City of Portland, Maine - Building or Use Permit Application
389 Congress Street, 04101 Tel: (207) 874-8703, Fax: (207) 874-8716

Permit No: 02-1012	Issue Date: EOT 18 2002	CBL: 057 K001001
-----------------------	----------------------------	---------------------

Location of Construction: 208 Danforth St	Owner Name: Dana Thomas H	Owner Address: 715 Chandler's Wharf	Phone: 207-772-9578
Business Name:	Contractor Name:	Contractor Address:	Phone:
Lessee/Buyer's Name	Phone:	Permit Type: Alterations - Dwellings	Zone: R-6

Re: 208 Danforth Street – exterior alterations

PROPOSED DECK:

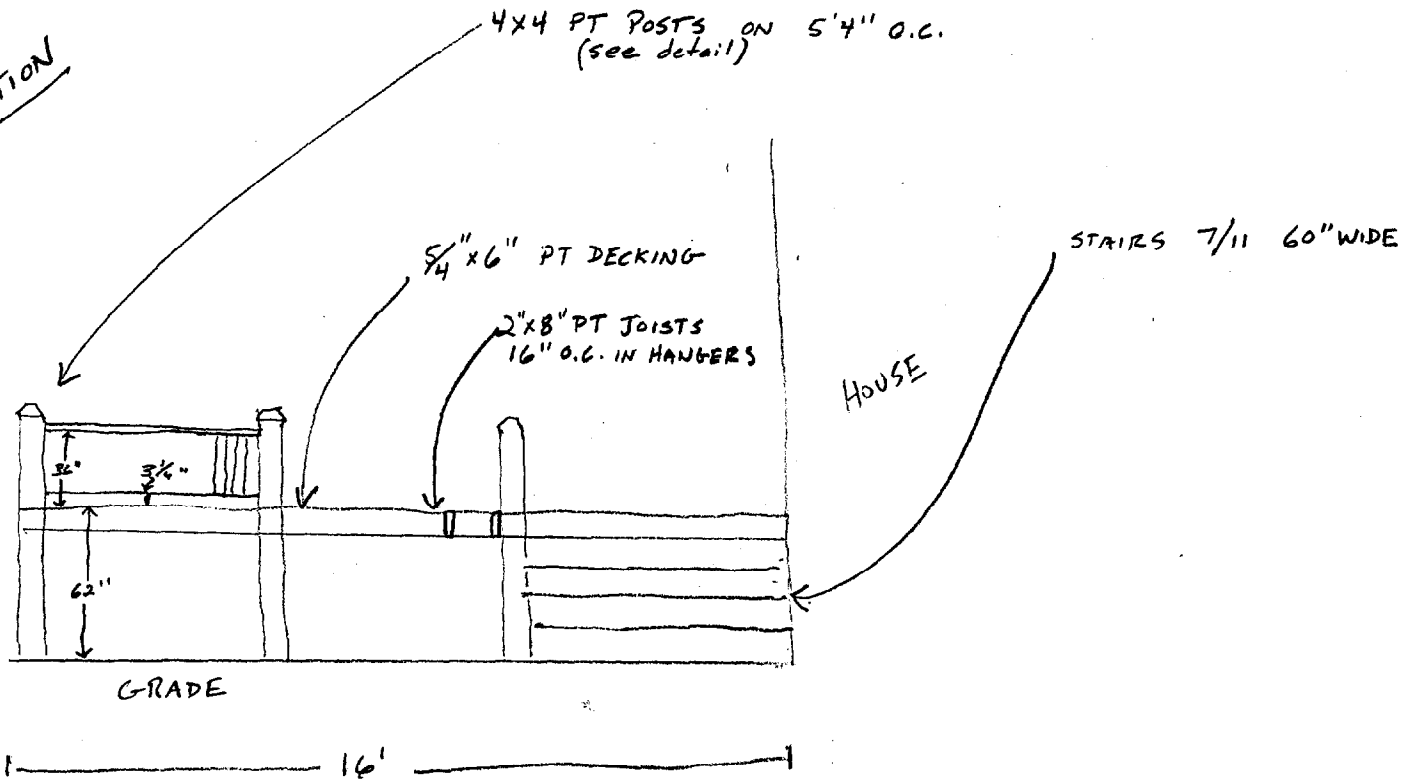
Band Joist must be DOUBLE 2"x 8" minimum. Joist hangers on all joists. Ledger/ Band affixed to house must be Flashed, Lagged in a structurally appropriate manner

All guards must be 36" with openings less than 4 inches, handrails must be graspable.

This permit is being approved on the basis of plans submitted. Any deviations shall require a separate approval before starting that work. It is understood that the new porch will be within the footprint of the existing deck/fire escape.
